**From:** David Henderson <david.henderson@mercergov.org>  
**Sent:** Wednesday, July 3, 2019 9:49 AM  
**To:** Larz Hitchcock  
**Subject:** RE: Kyle Griffith Deck Permit

**From:** Larz Hitchcock <Larz.Hitchcock@jacksonmain.com>  
**Sent:** Wednesday, July 3, 2019 8:11 AM  
**To:** David Henderson <david.henderson@mercergov.org>  
**Subject:** RE: Kyle Griffith Deck Permit

At this time the application is deemed to be incomplete as it is missing the following information. **Please upload all documents per the Mie plan process**, clarifying the proposed scope of the project. Once the application is deemed to be complete, the project will be routed as express review for Civil, Tree, Building and Planning staff approval.

DEMOLITION PLAN
A1.01
JACKSON | MAIN ARCHITECTURE P.S. © 2019

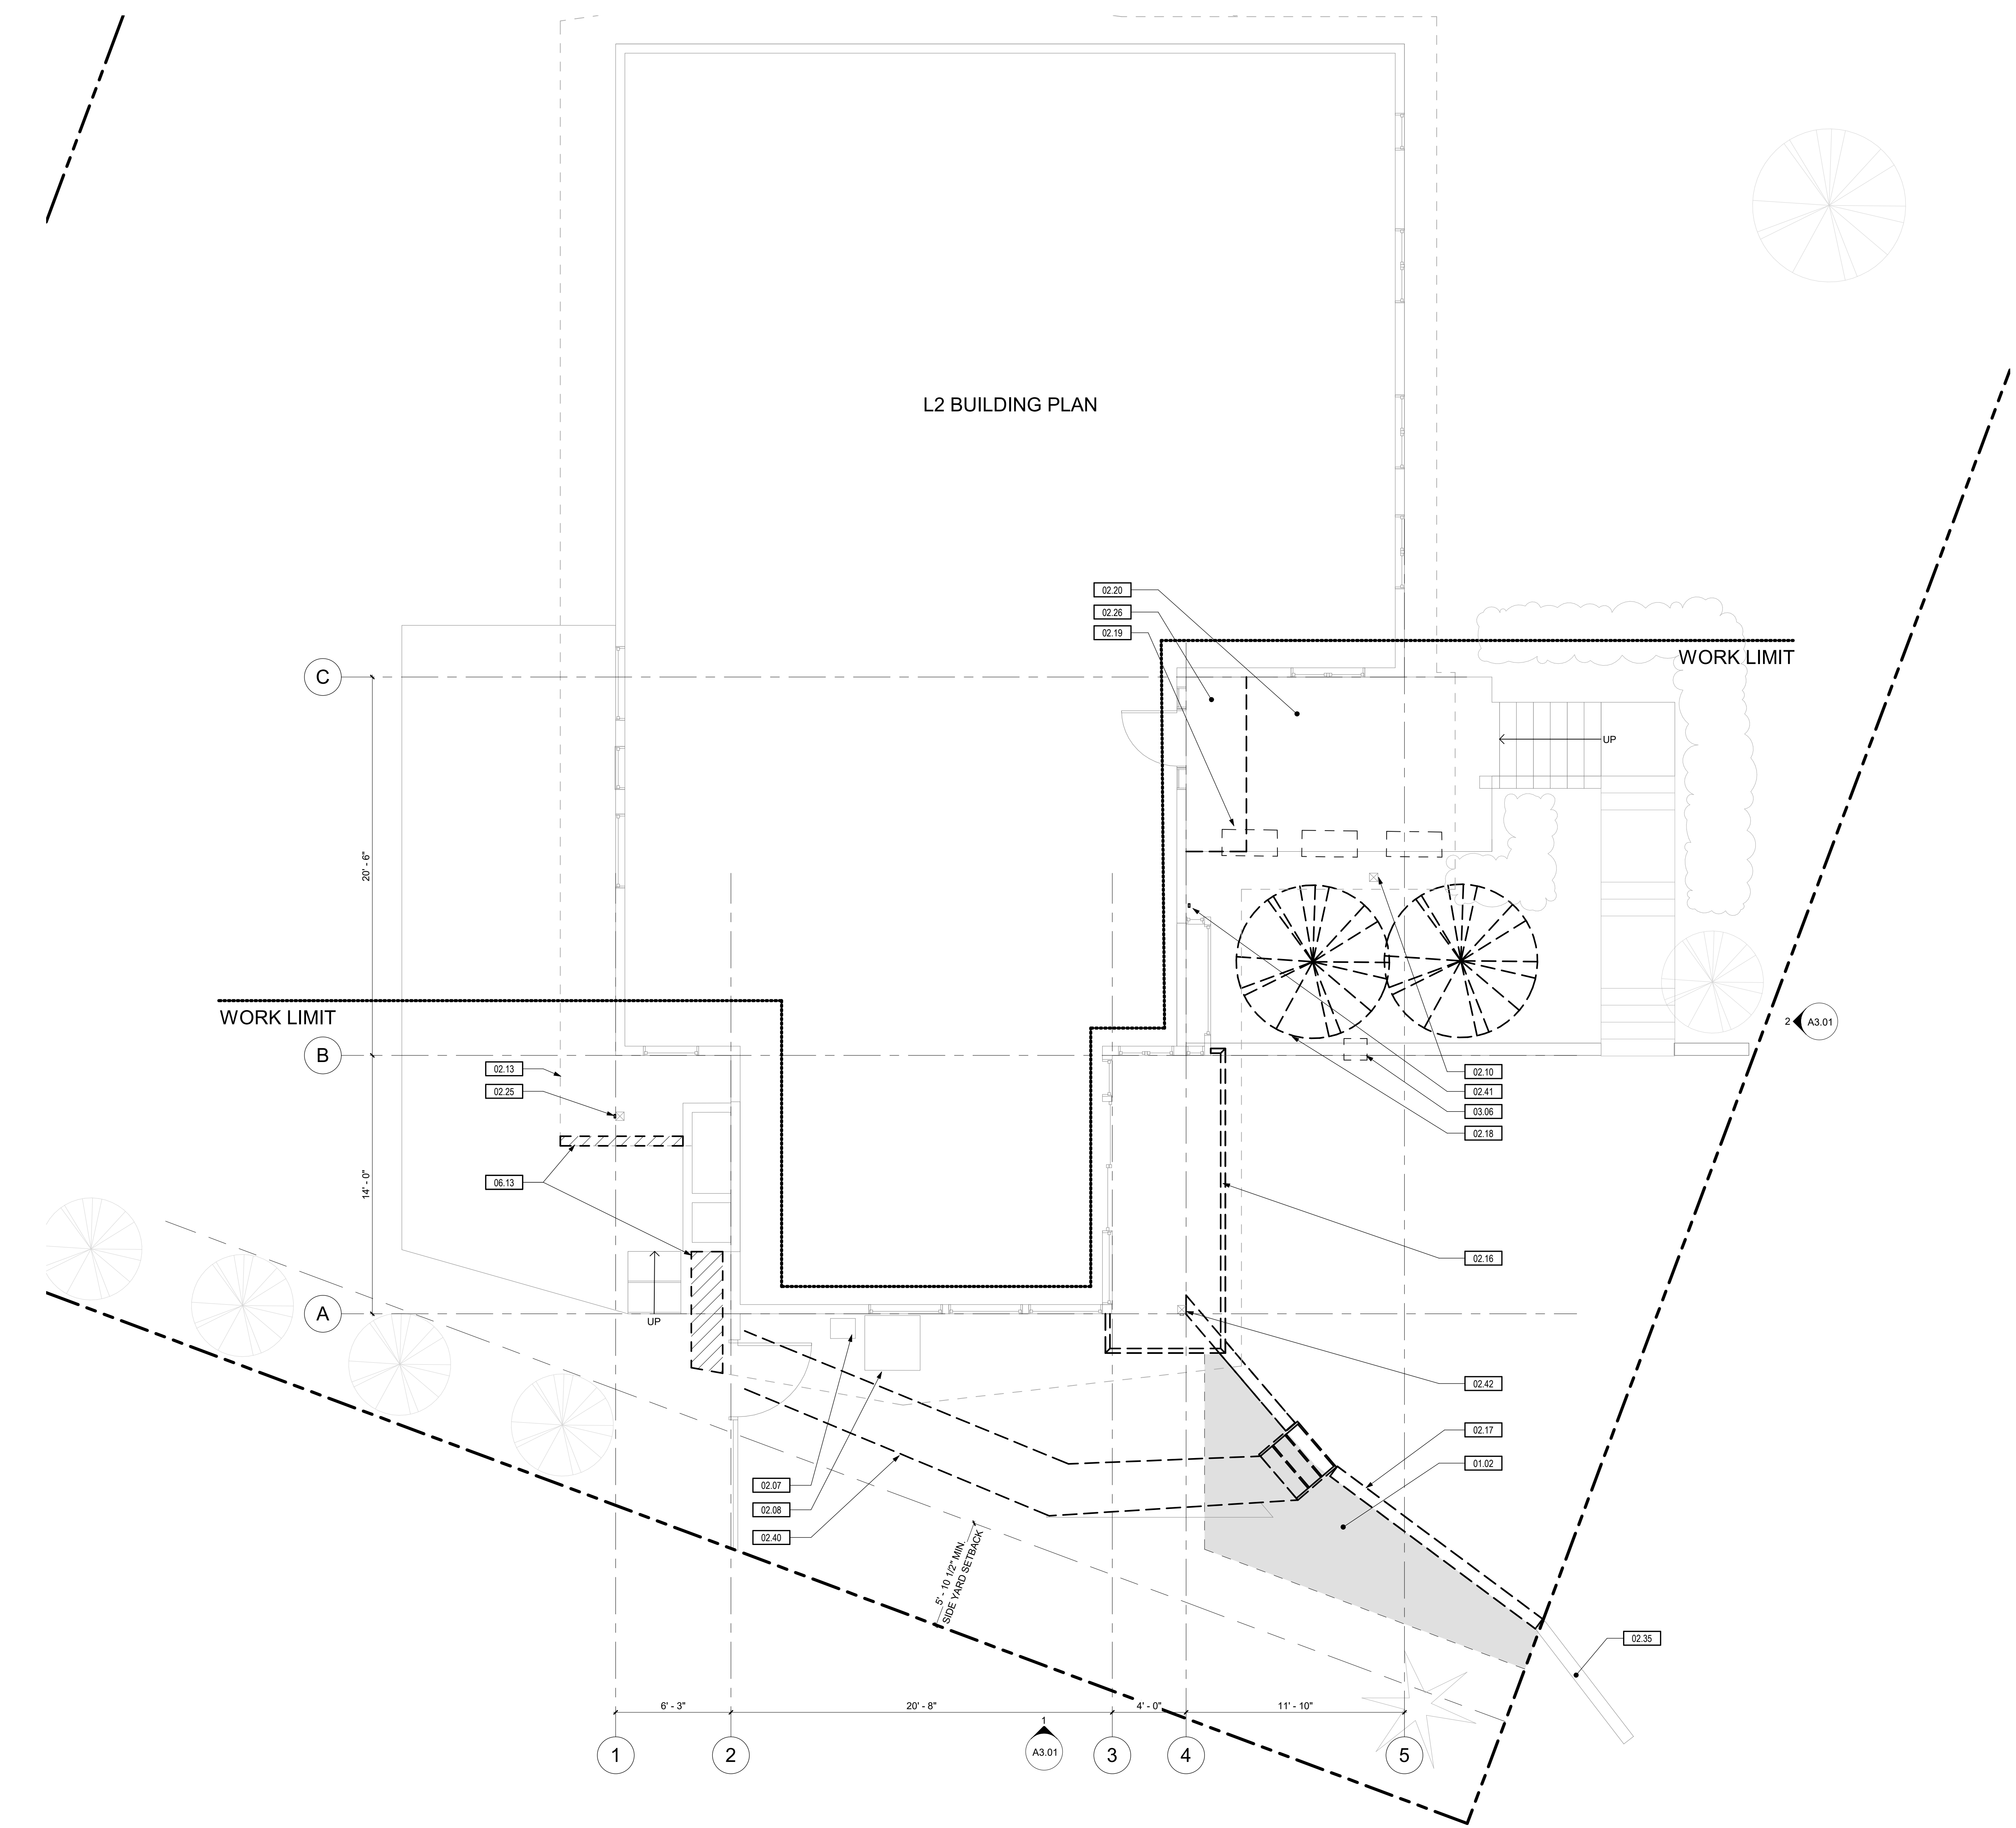
Once I was able to review the full scope of the project, I determined that includes the removal and replacement of a retaining walls, including a portion that is located in the right of way and is immediately adjacent to an existing tree of unknown species and size.

Prior to permit approval, you will most likely need to apply for an encroachment agreement and apply for a right of way use permit for proposed work in the Right of Way.

**We are removing all work within the Row. Plans A1.01, A2.01 and adjusted**

**We are removing all work within the ROW, All plans adjusted to show this.**

7 SMALL RETAINING WALL SECTION
 3" = 1'-0"

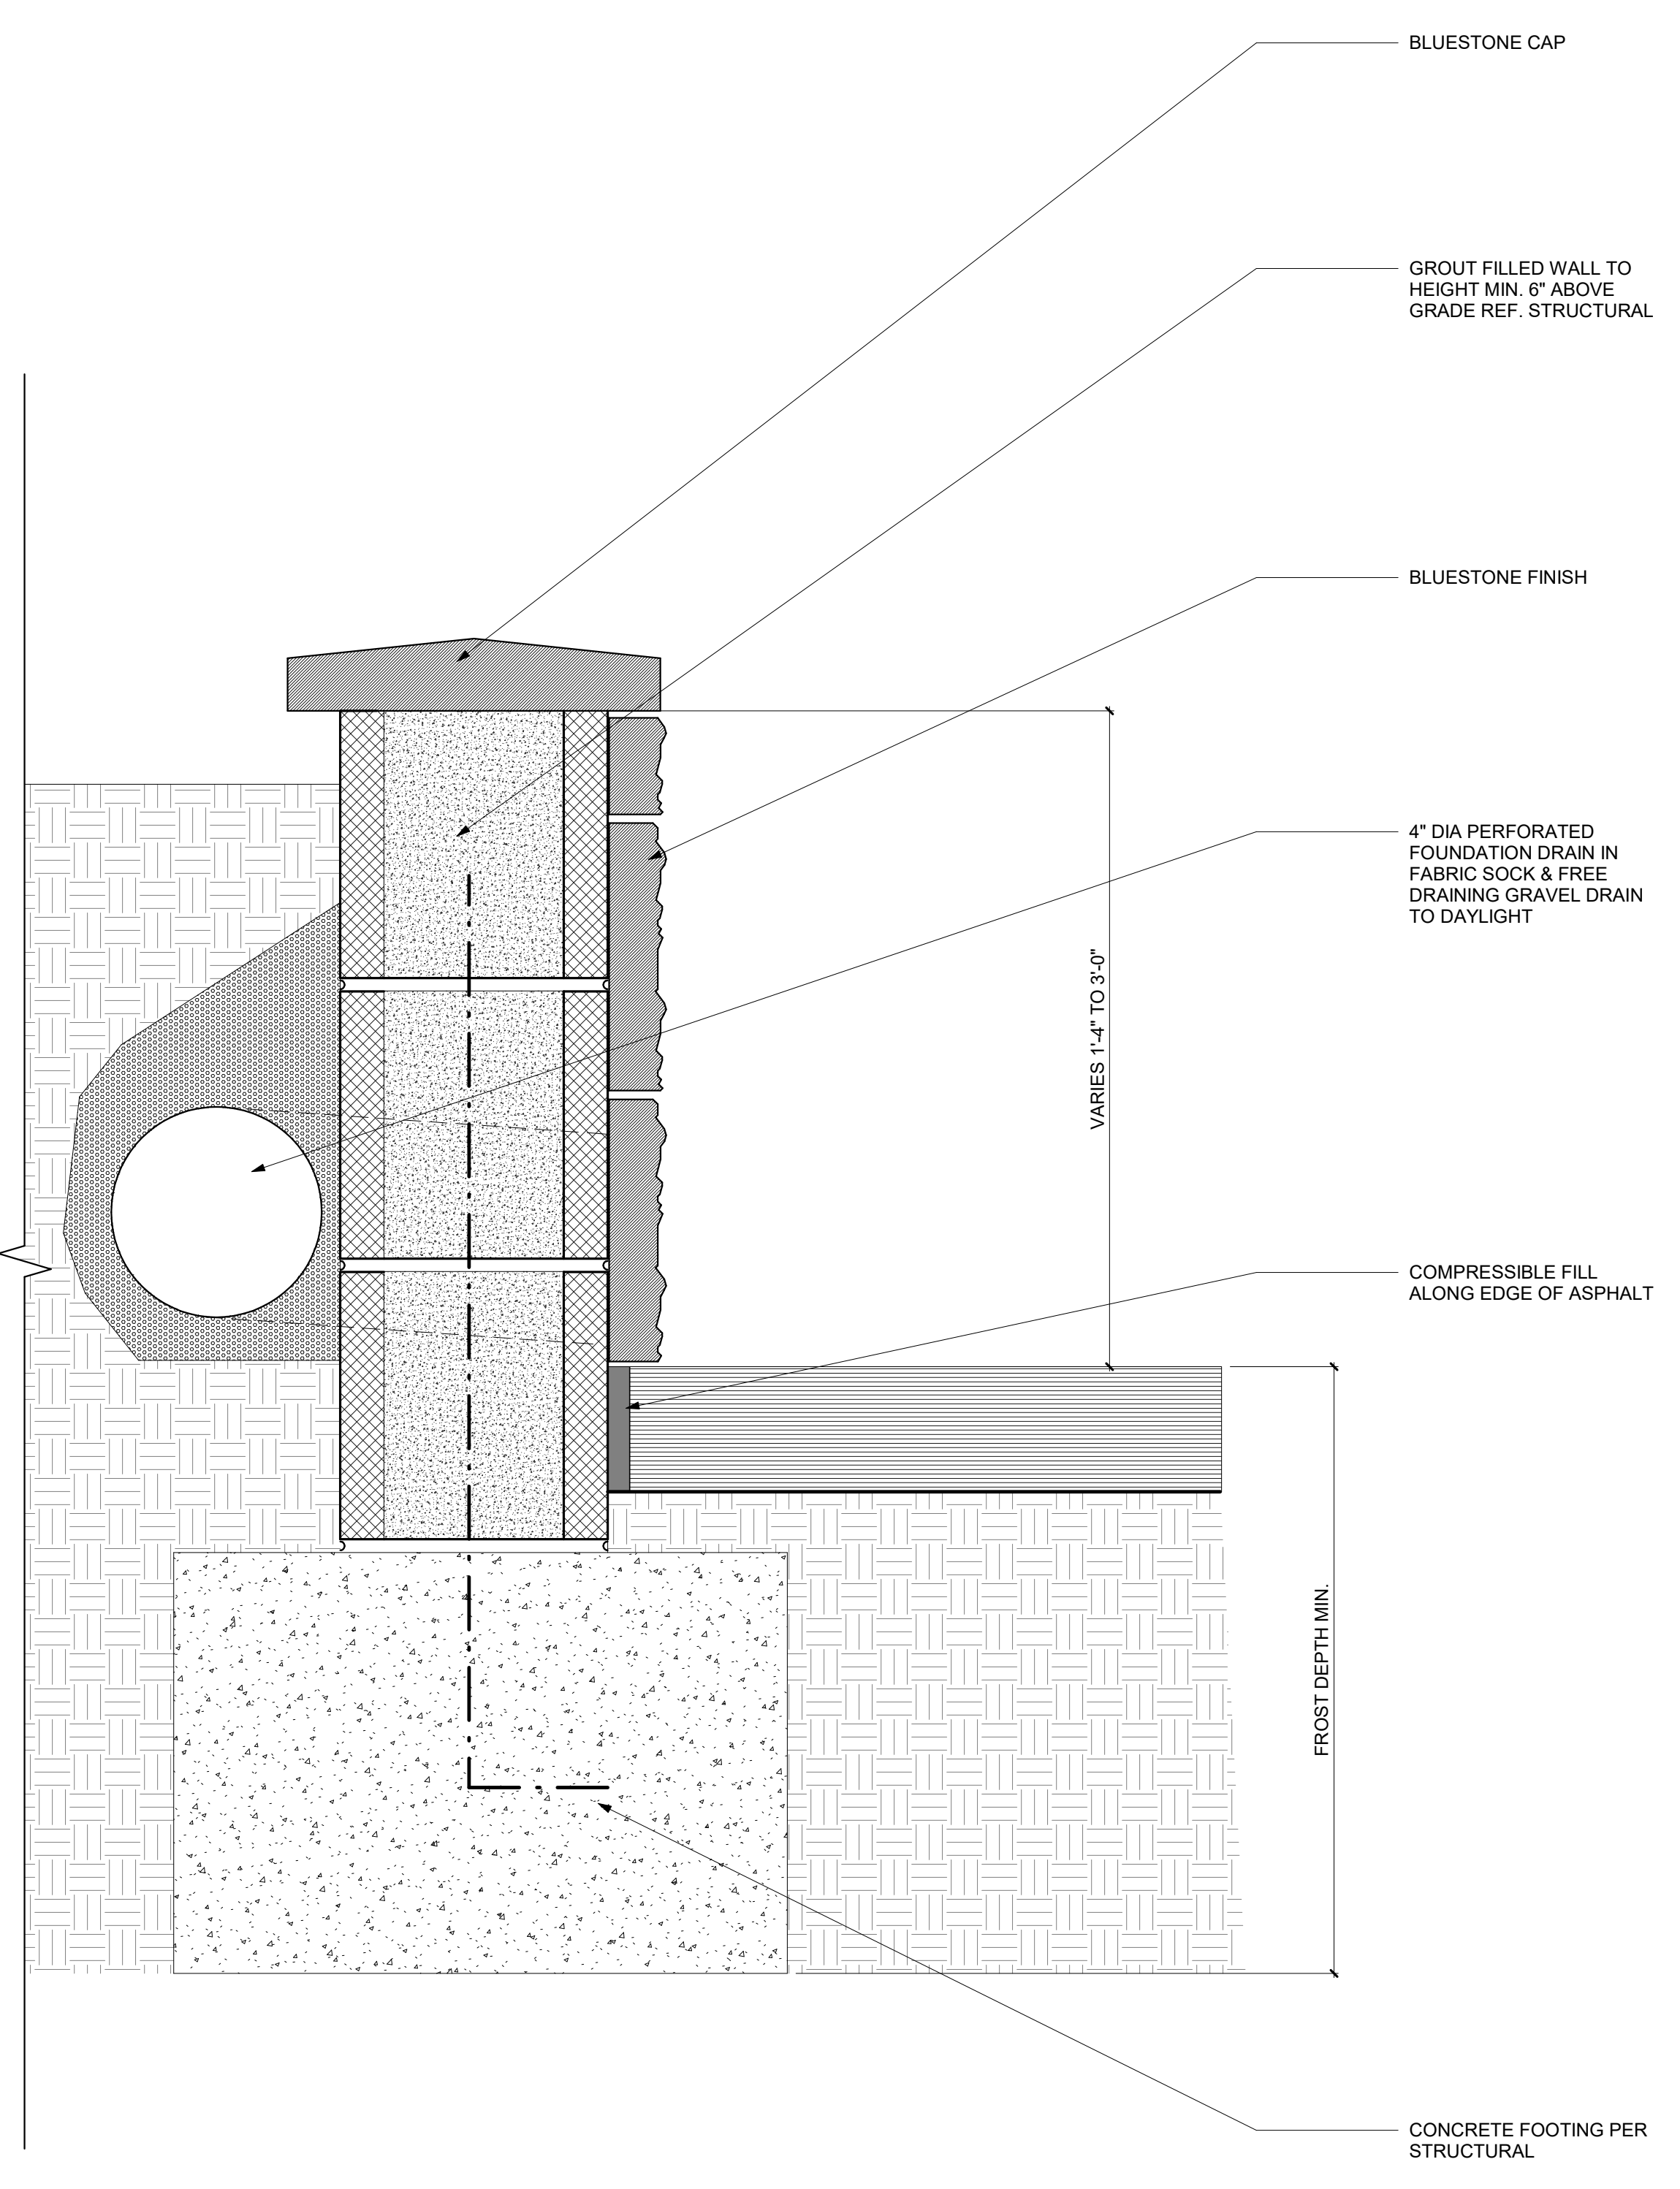
They also need T.O.W & B.O.W. elevations for the replacement retaining wall.

There is no drainage shown for the retaining wall and this needs to be tight lined to an approved location.

We have added this information with new detail 7/A8.01. Height of wall varies from 16 to 36" tall.

We have added this information with new detail 7/A8.01.
